Rezoning Transportation Analysis

Petition Number: 2022-210

General Location Identifier: 14506122, 14506121, 14506128, 14506120, 14606126

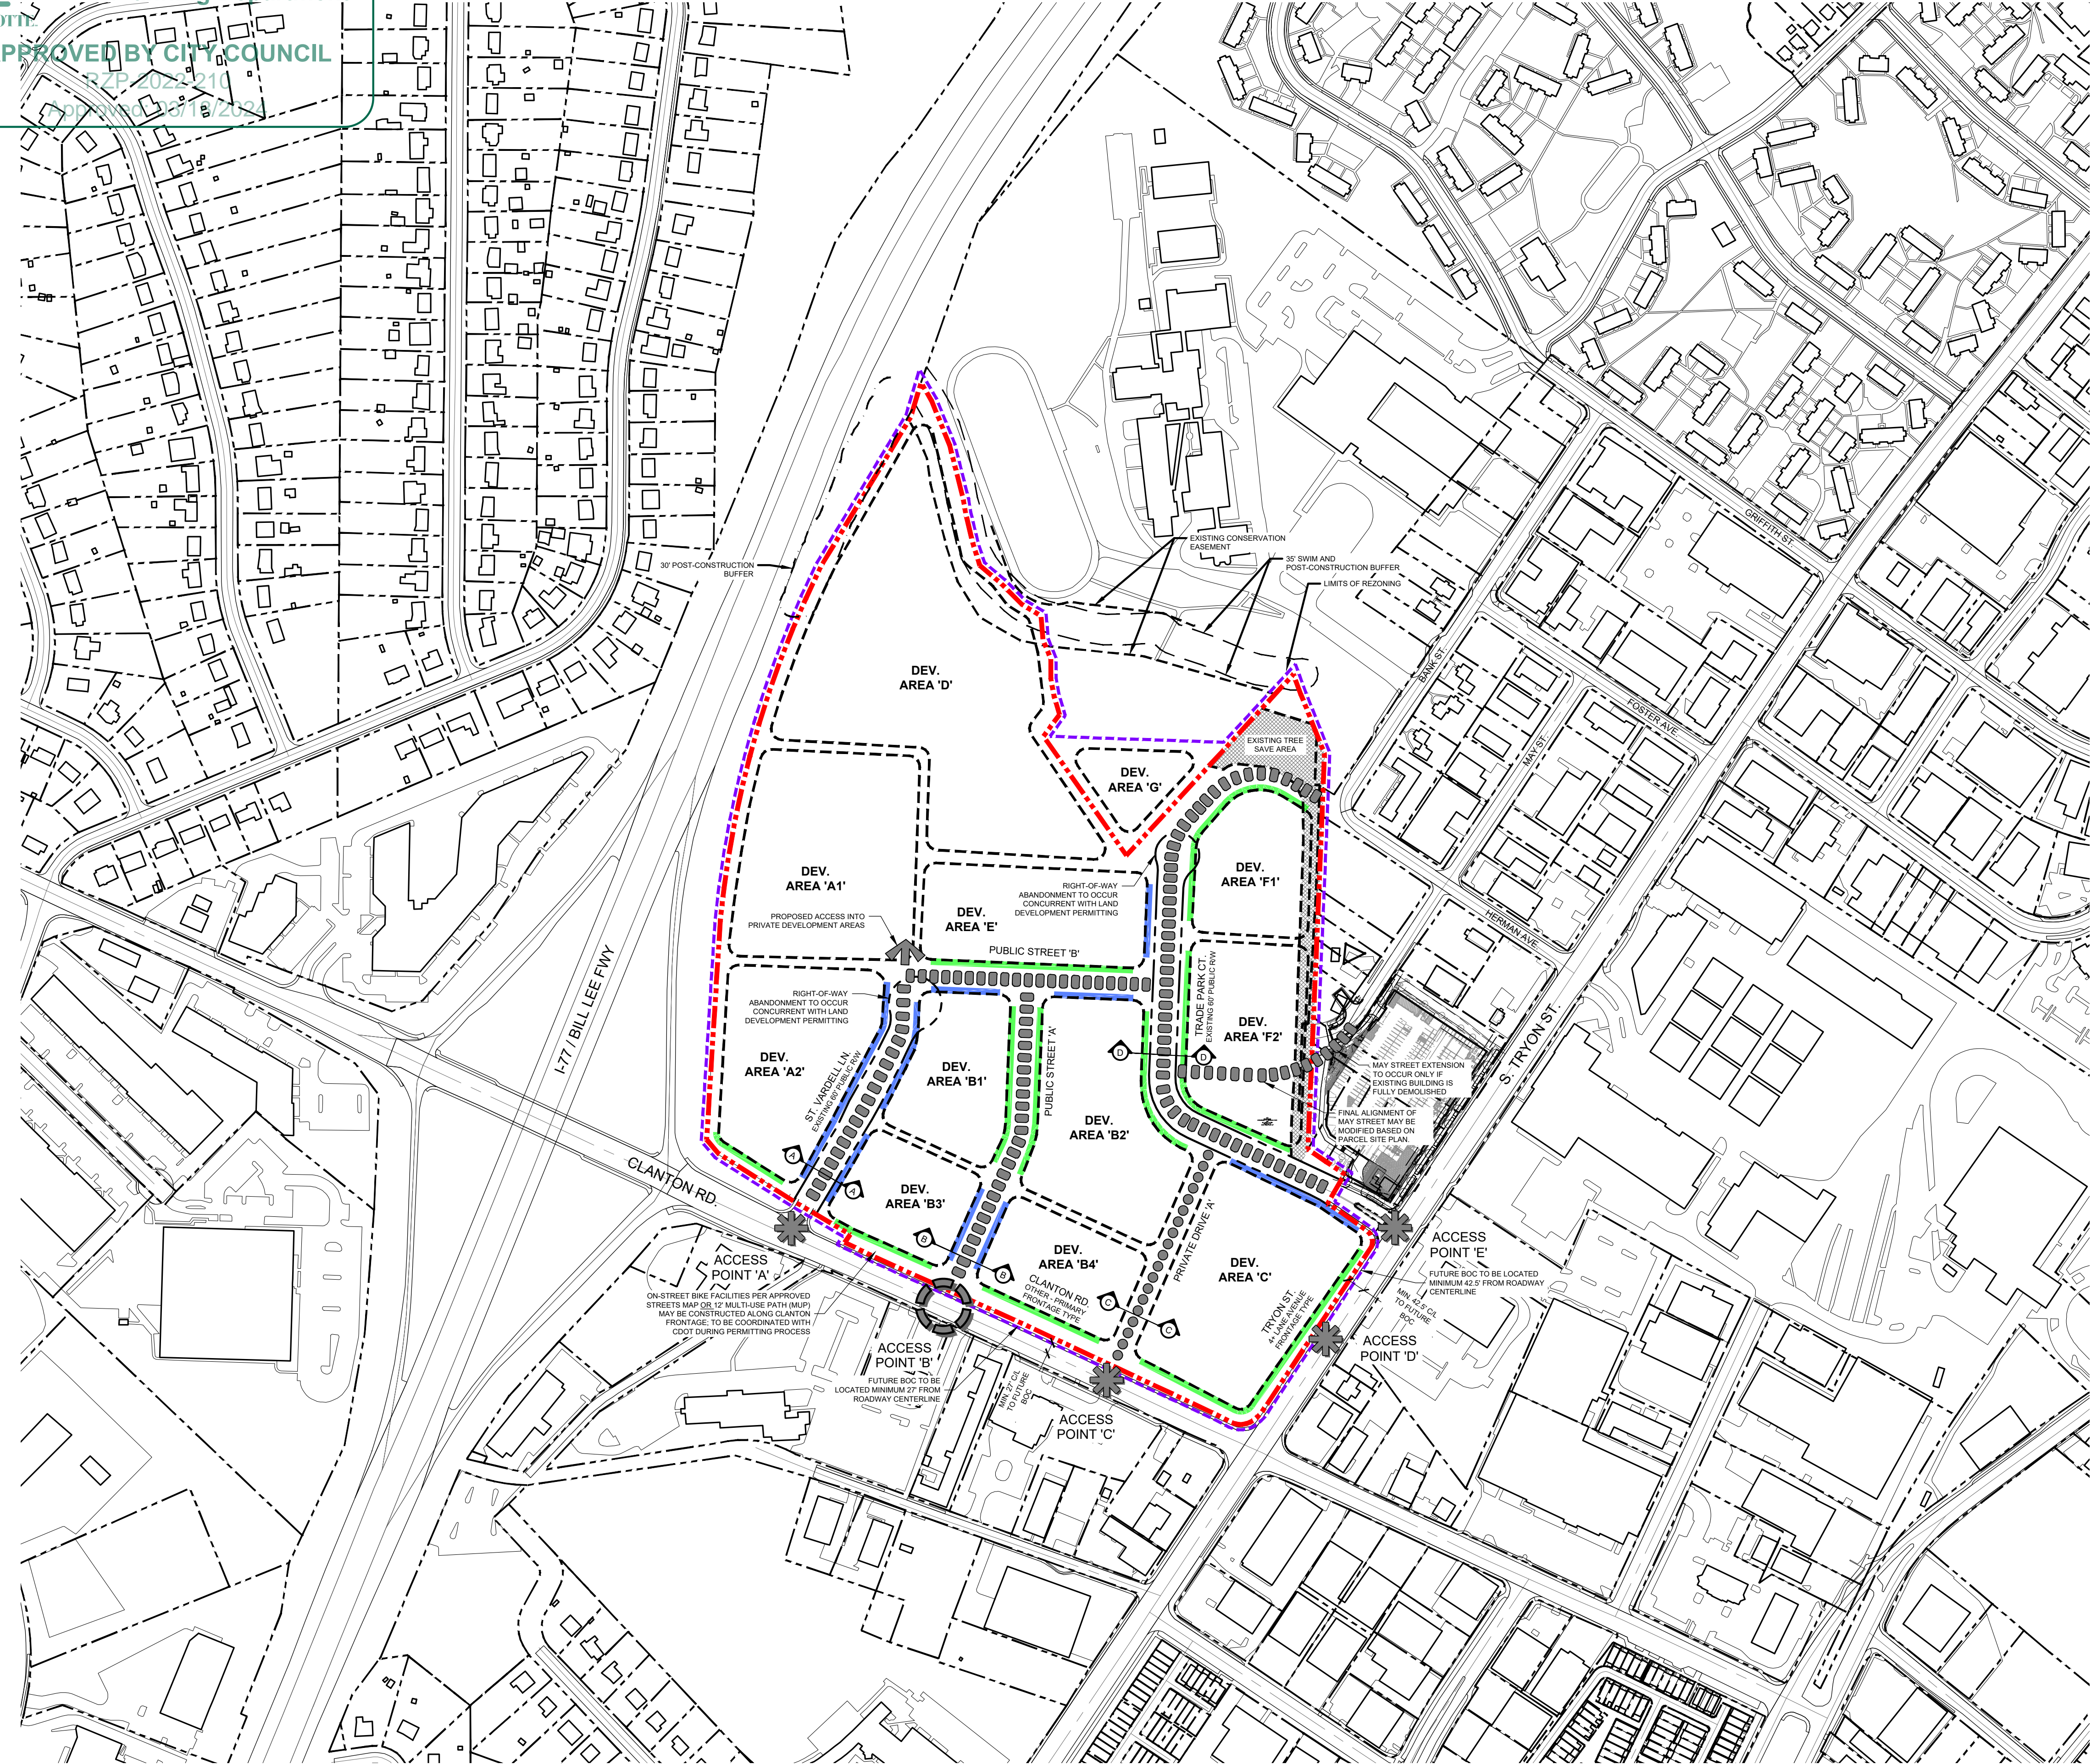
- a. ~~South Tryon Street: Location of curb and gutter to be moved a minimum of 42.5 feet from roadway centerline to accommodate the Charlotte Streets Map with a roadway typical section of a 4+ Avenue with Buffered/Separated Bike Lanes and On-Street Parking.~~

- b. ~~Clanton Road: Location of curb and gutter to be moved a minimum of 27 feet from roadway centerline to accommodate the Charlotte Streets Map with a roadway typical section of a 2+ Avenue with Buffered/Separated Bike Lanes.~~

Outstanding Comment 9.20.23: ~~Label and dimension the curb and gutter from the centerline for each road on the site plan.~~

Clarifying comment 6.21.23: ~~Label and dimension the curb and gutter from the centerline for Clanton Road and South Tryon Street.~~

- ~~3. Revise site plan and conditional note(s) to commit to dedicate a minimum of 50 feet of right-of-way from the road centerline of South Tryon Street and Clanton Road. The site plan shall label and dimension the right-of-way from the road centerline.~~

~~**Clarifying comment 6.21.23:** Label and dimension a minimum 50 feet of ROW from the road centerline of South Tryon Street and Clanton Road.~~

- ~~4. Revise site plan and conditional note(s) to commit to construct an 8-foot planting strip, and 8-foot sidewalk on South Tryon Street and Clanton Road per Chapter 19. The site plan shall label and dimension both items from the back of curb and gutter or edge of pavement.~~

~~**Clarifying comment 6.21.23:** Label and dimension 8-foot planting strip and 8-foot sidewalk from the back of curb and gutter or edge of pavement of South Tryon Street and Clanton Road.~~

3. The Petitioner shall dedicate a minimum of fifty (50) feet of right-of-way from the road centerline of South Tryon Street and Clanton Road.

4. The Petitioner shall construct an 8-foot planting strip, and 8-foot sidewalk on South Tryon Street and Clanton Road per Chapter 19.
